Refusal of Planning Permission

Reference: H16-0445-15 Received: 19th May 2015

Description: Two-storey rear extension and associated works

Location : 3 HILLARY CLOSE SPALDING

01 - Ground Floor Plan  
1 : 50

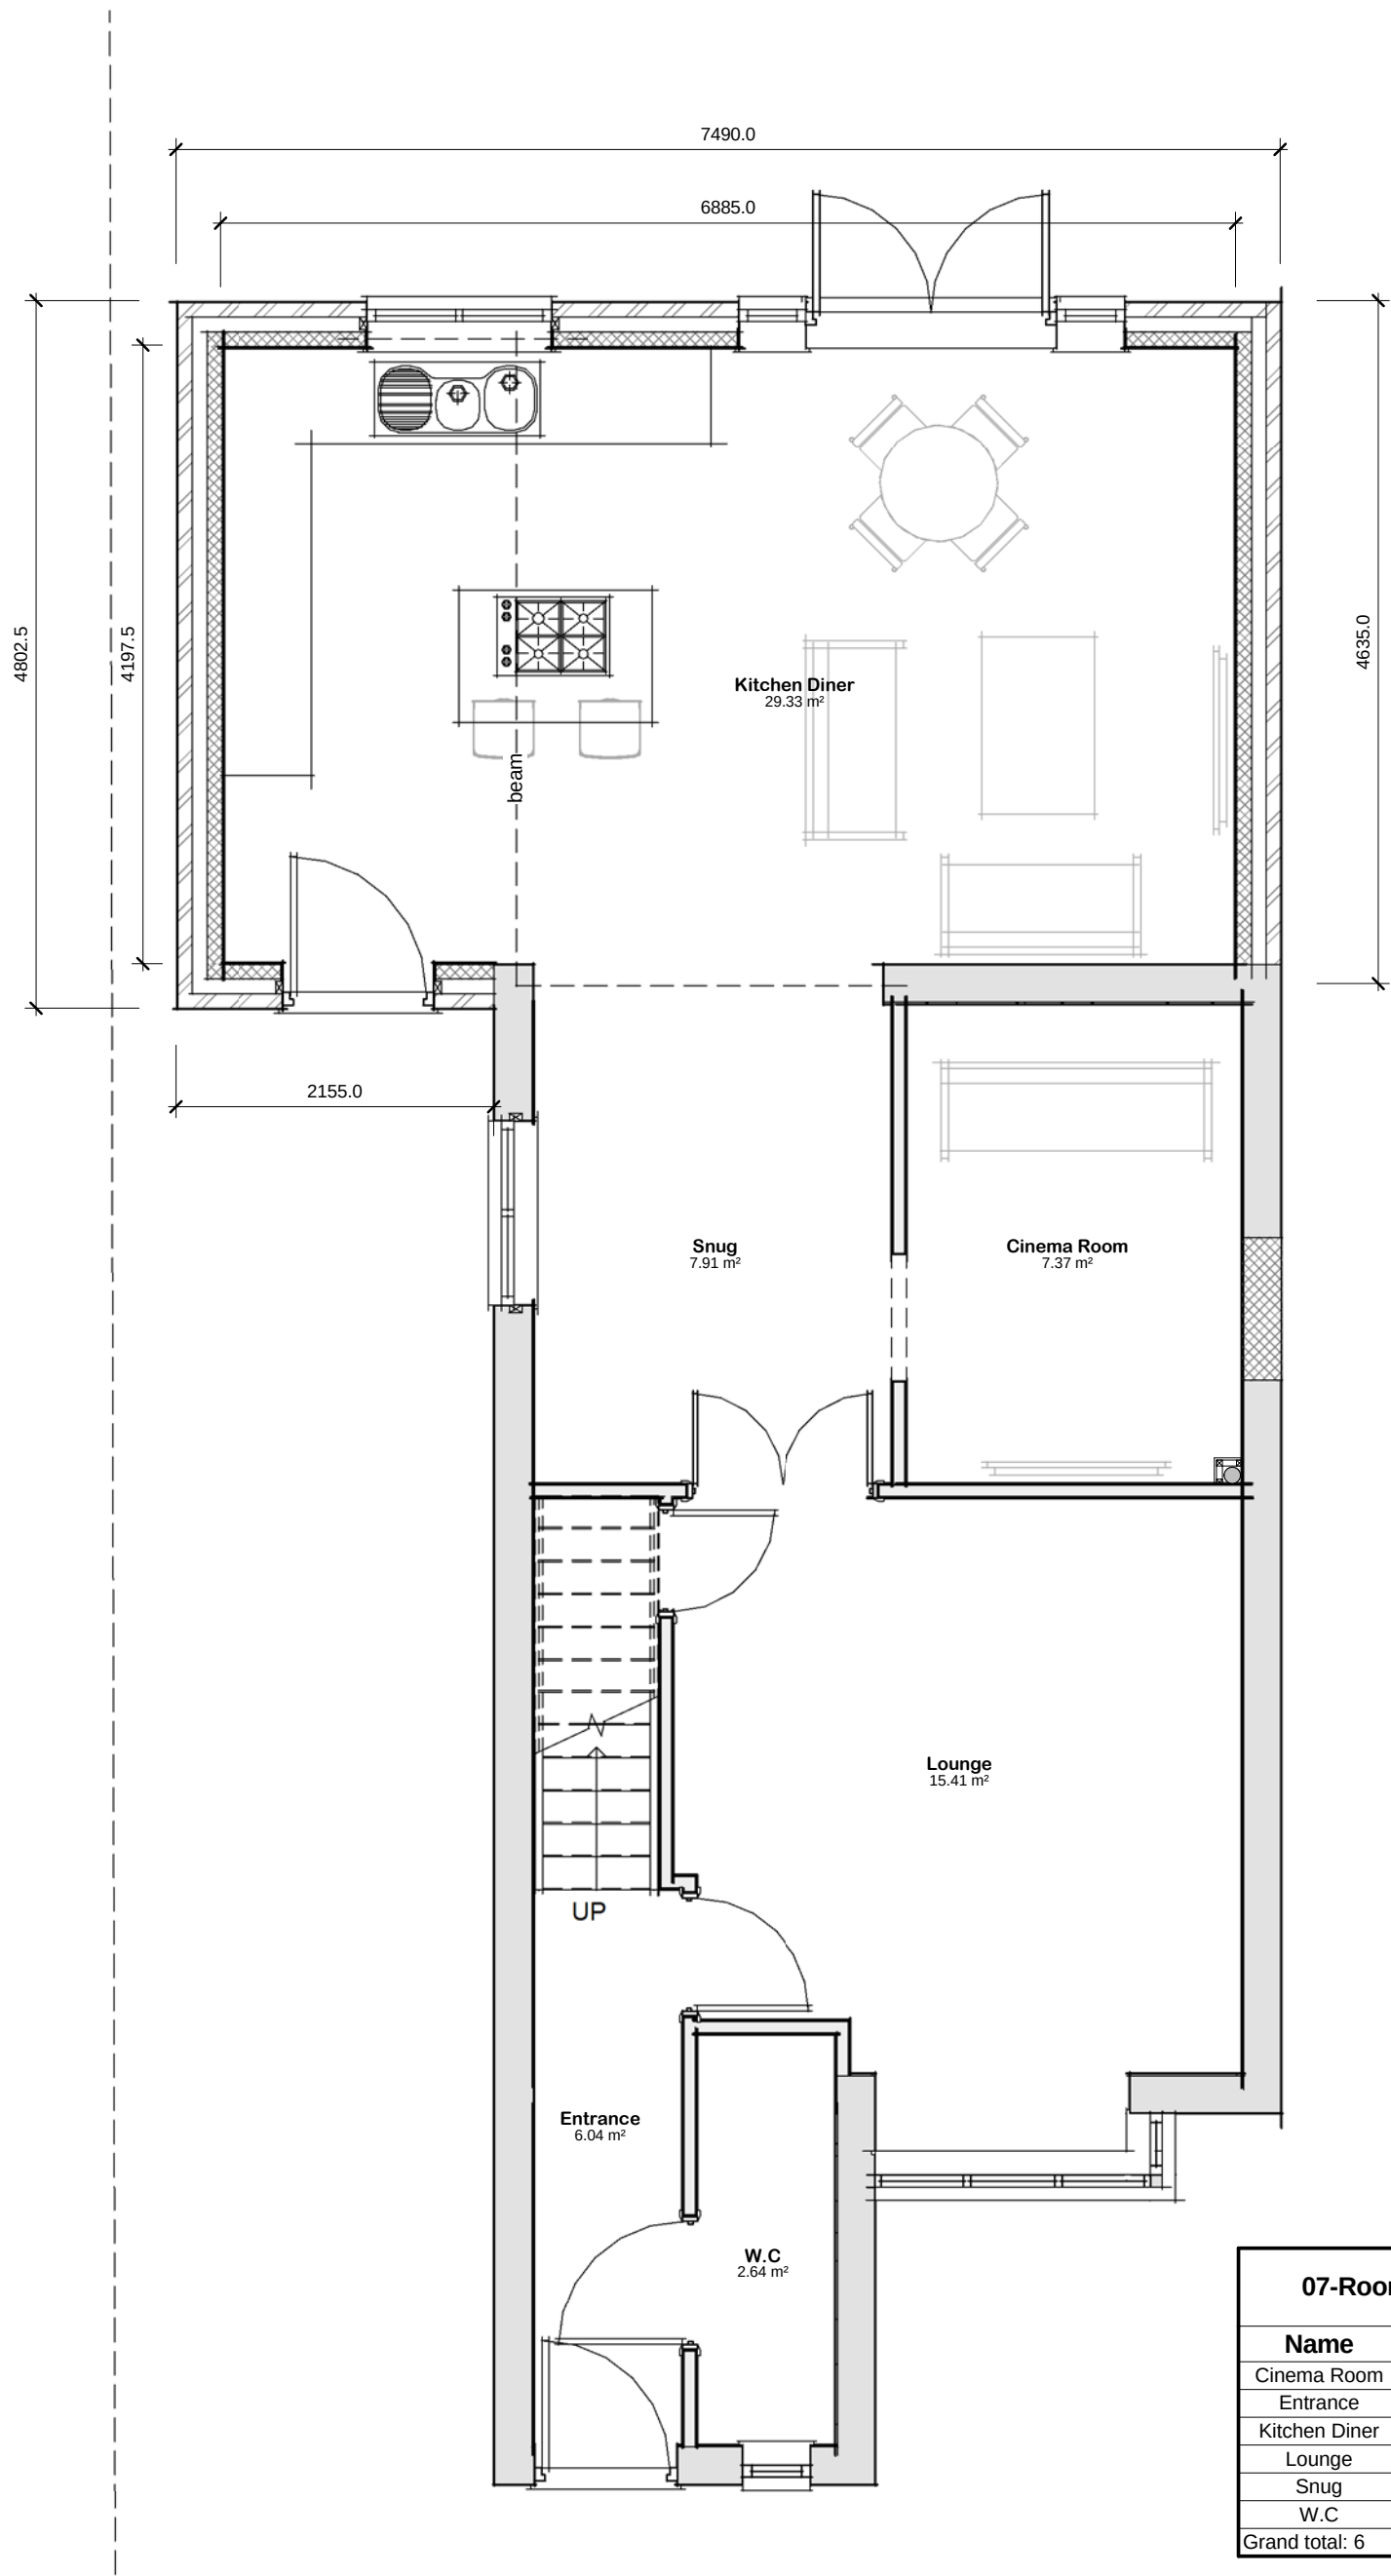
- 1 The proposed extension would, by reason of both its overall scale, massing, height and close proximity to the boundary, result in a significant impact and loss of amenity to the occupants of 4 Hillary Close to the east in terms of overlooking, overbearing and overshadowing. The proposal is therefore contrary to Policies SG17 and SG20 of the South Holland District Local Plan, 2006. These policies indicate that new development should maintain the amenity of neighbouring residents (both existing and future) and are in accordance with Section 7 "Requiring Good Design" of the National Planning Policy Framework 2012.
